# 2023 Financial Assurance Estimate Form (with pre-plat construction)

PROJECT INFORMATION			
Project Name	Waterbury Filing No. 1	Date	2/6/2023
PCD File No.	PUDSP 21-005

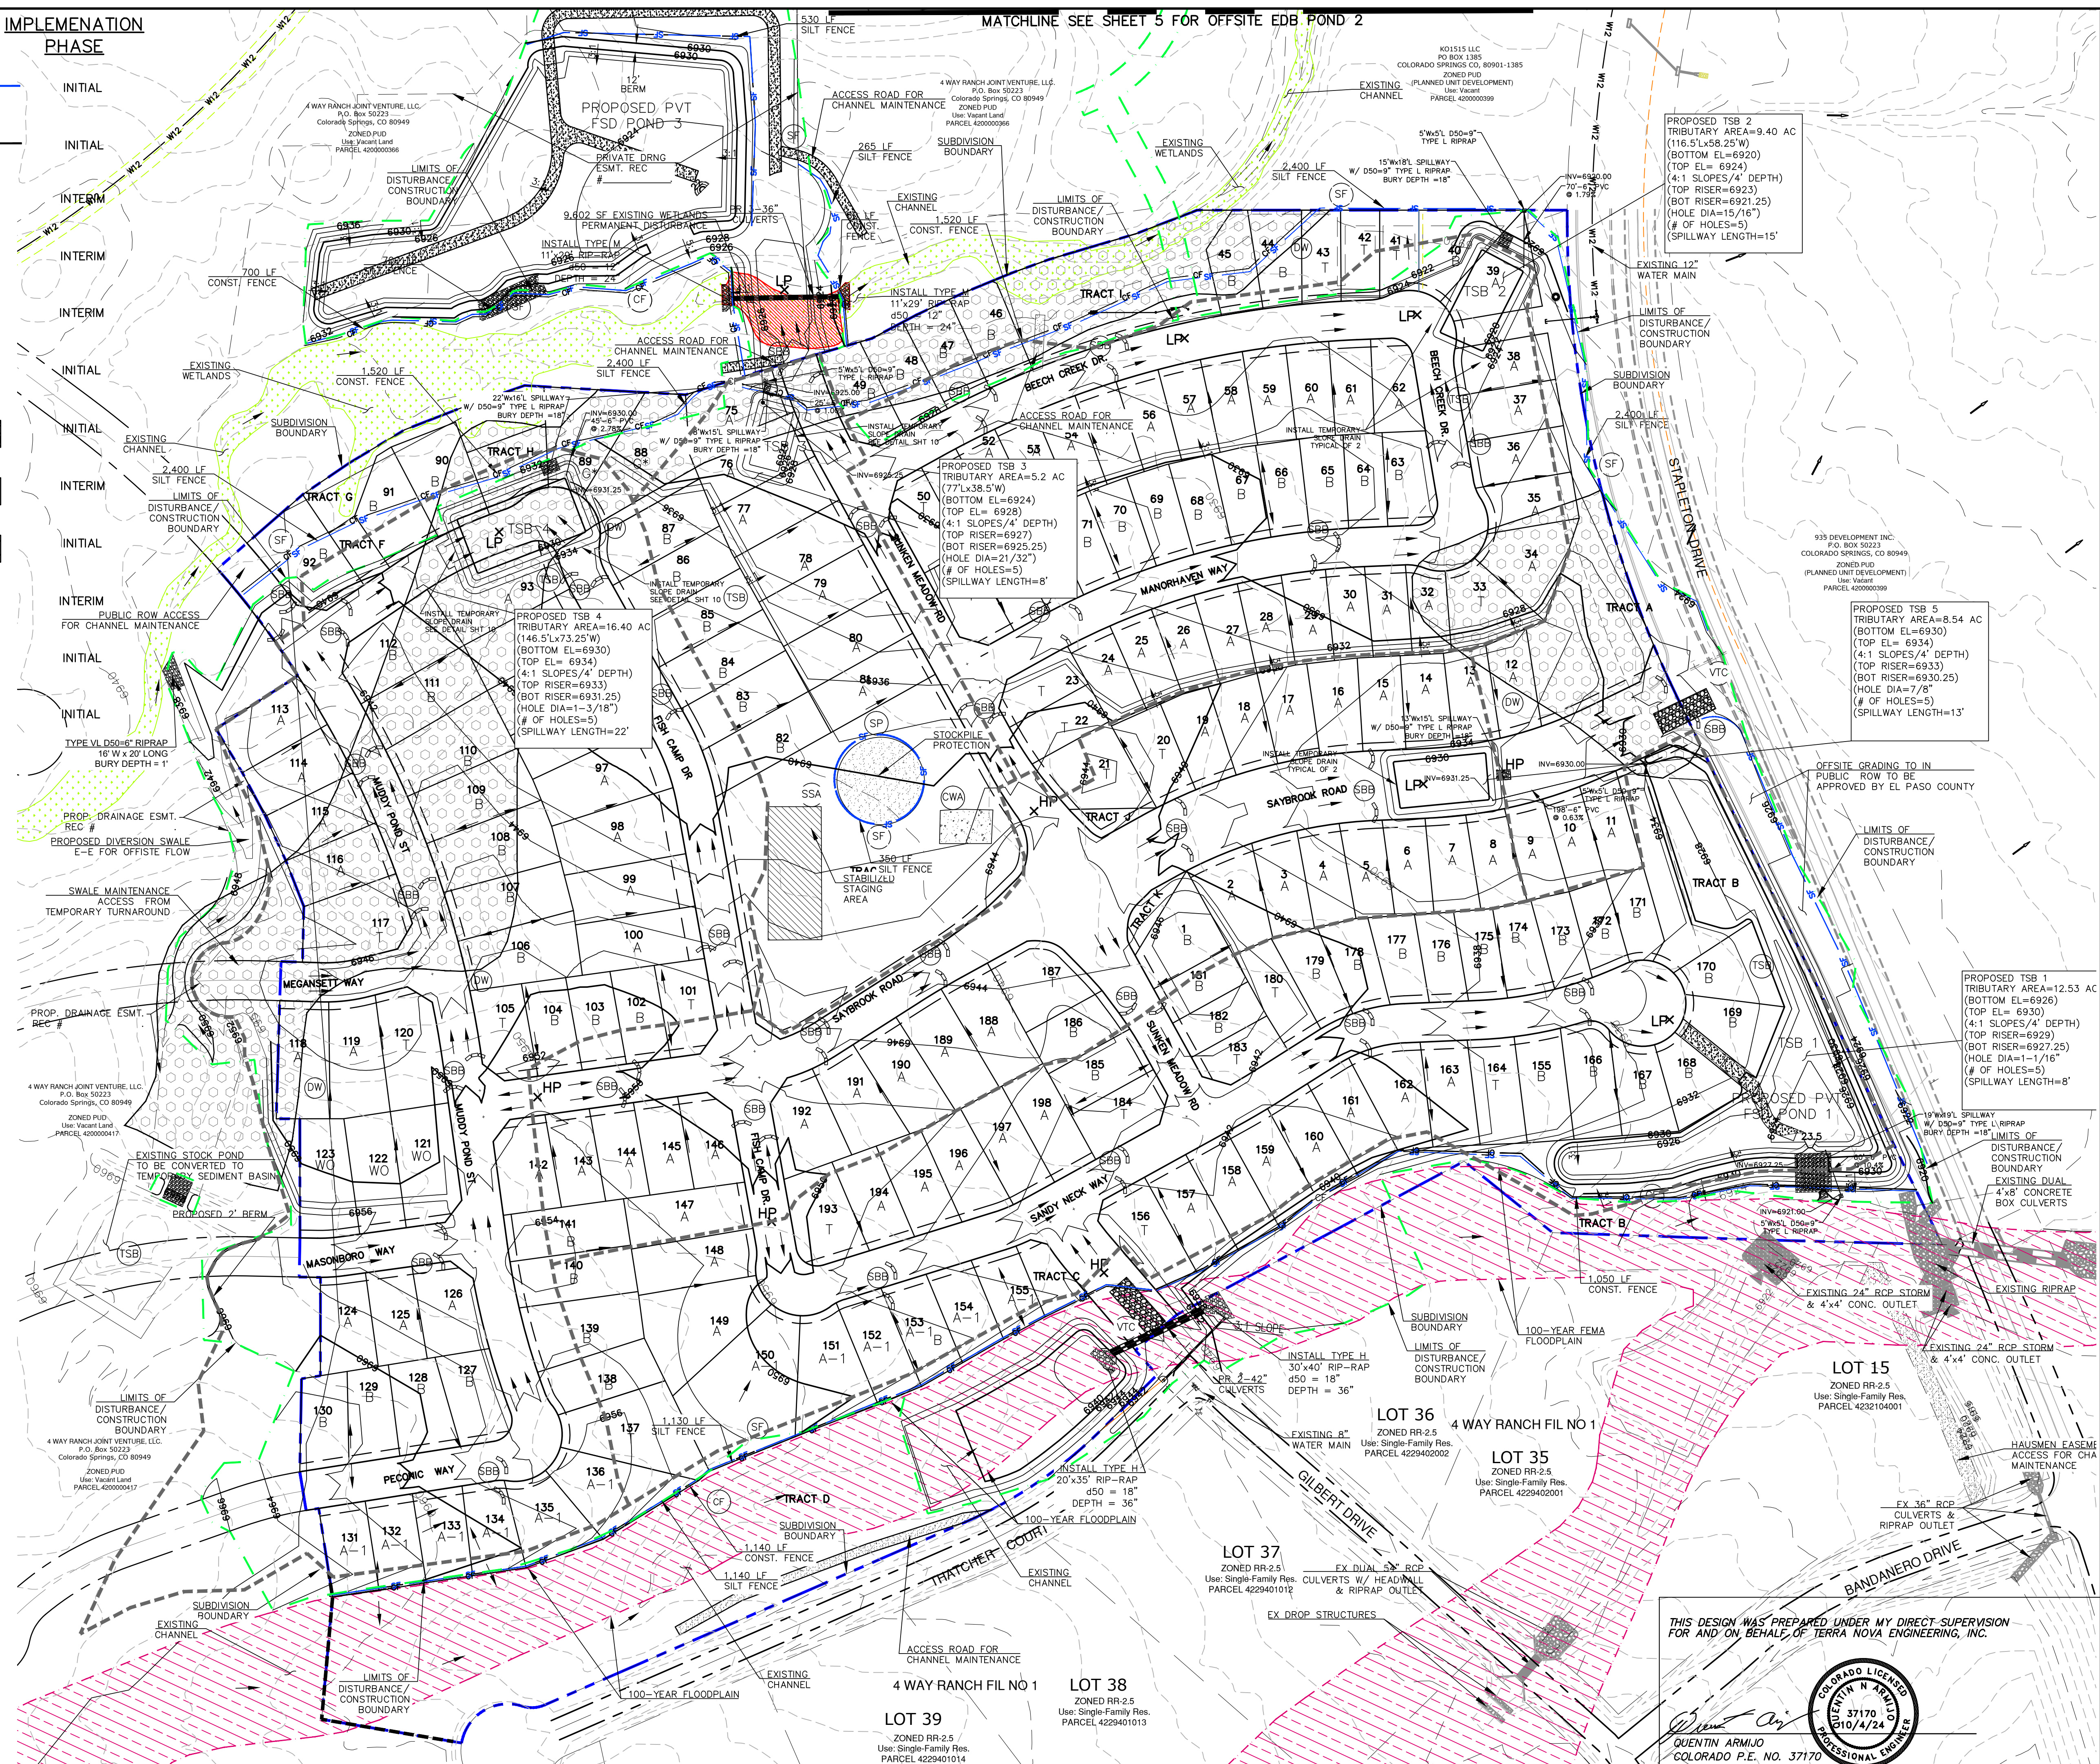
GEC plan states est area of disturbance is 68.7 ac. With only 9 ac permanently seeded what happens to the other 60 ac? Provide temp seeding and mulching and/or surface roughening.

Show on GEC plan if proposed.

SAYBROOK AND ROUNDABOUT SIGNING & STRIPING

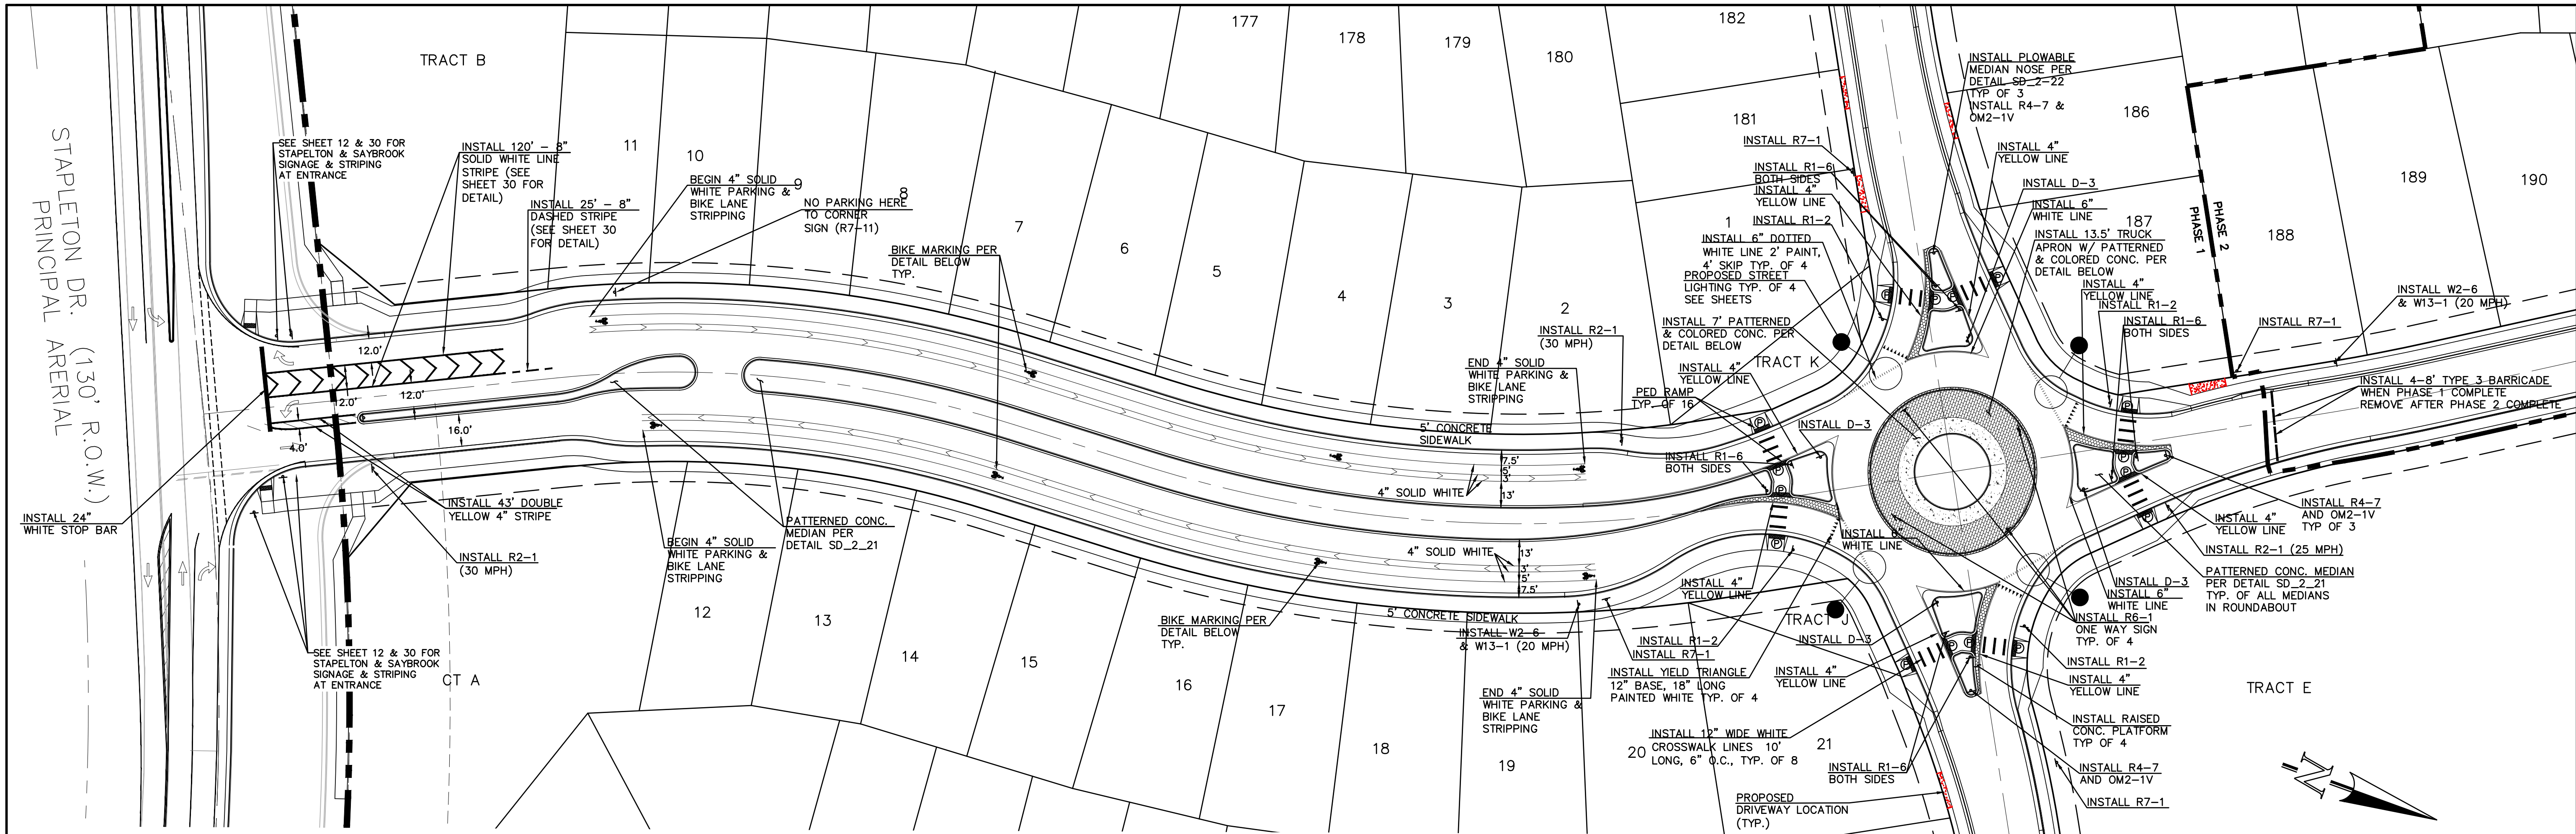
This value seem very low considering roundabout signage, signs at Stapleton int, interior intersection stop signs, and stop sign at Gilbert & Thatcher. Account for all signage and update accordingly
